Our Case Number: ACP-323066-25

Re: Gort Town Centre Public Realm Enhancement Project, Gort, Co. Galway
In the townlands of Gort, Co. Galway

Re: Submission on the Gort Town Centre Public Realm Enhancement Project – Opposition to the Lowering of the Christ the King Statue Plinth (Drawing Ref: 3160-BDP-00-XX-SE-L-0007)

PROJECT TITLE	
GORT TOWN CETRE	
P3001253	
DRAWING TITLE	SCALE @ A1
LANDSCAPE SECTION F EXISTING & PROPOSED	1:50
	DATE
	23.10.23
DRAWING NO.	REVISION
3160-BDP-00-XX-SE-L-0007	P01

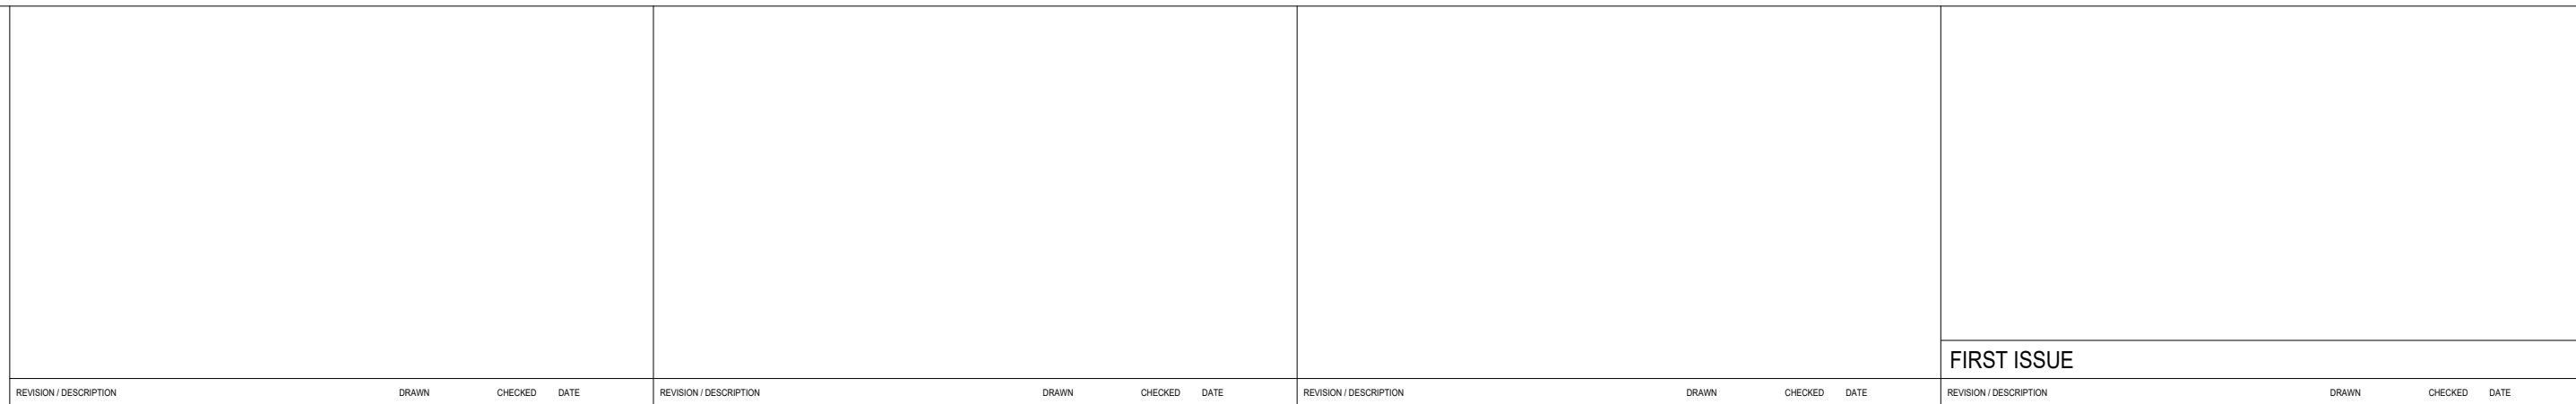
While we welcome the overall intent to improve the town centre and public spaces, we wish to raise a strong objection to the specific proposal to **lower the plinth of the Christ the King statue**, as detailed in drawing reference 3160-BDP-00-XX-SE-L-0007. This aspect of the proposal is inconsistent with proper planning and sustainable development and presents an unacceptable level of risk to a protected and much-valued cultural asset.

The Christ the King monument is a protected structure with a Regional rating on the National Inventory of Architectural Heritage (Reference: 30341016). The sculpture, crafted by the renowned Irish artist **Albert Power** with a plinth designed by **Thomas Cullen**, was commissioned by local woman Ann Coen in memory of her son. Lowering the plinth would materially alter the original artistic and architectural intent and would diminish the monument's recognised heritage and artistic value.

The process of lowering the plinth introduces a substantial risk of damaging this historic and delicate marble statue. Such an intervention could lead to irreversible harm, a risk that far outweighs any perceived aesthetic or functional benefit of the proposed change.

Reducing the height of the plinth would bring the statue within easy reach of pedestrians, increasing the likelihood of accidental damage, vandalism, or erosion through handling. The current elevated position provides a natural safeguard for this fragile piece of public art.

We request that this element of the proposal be omitted or revised to ensure the full preservation of the Christ the King statue and its plinth.
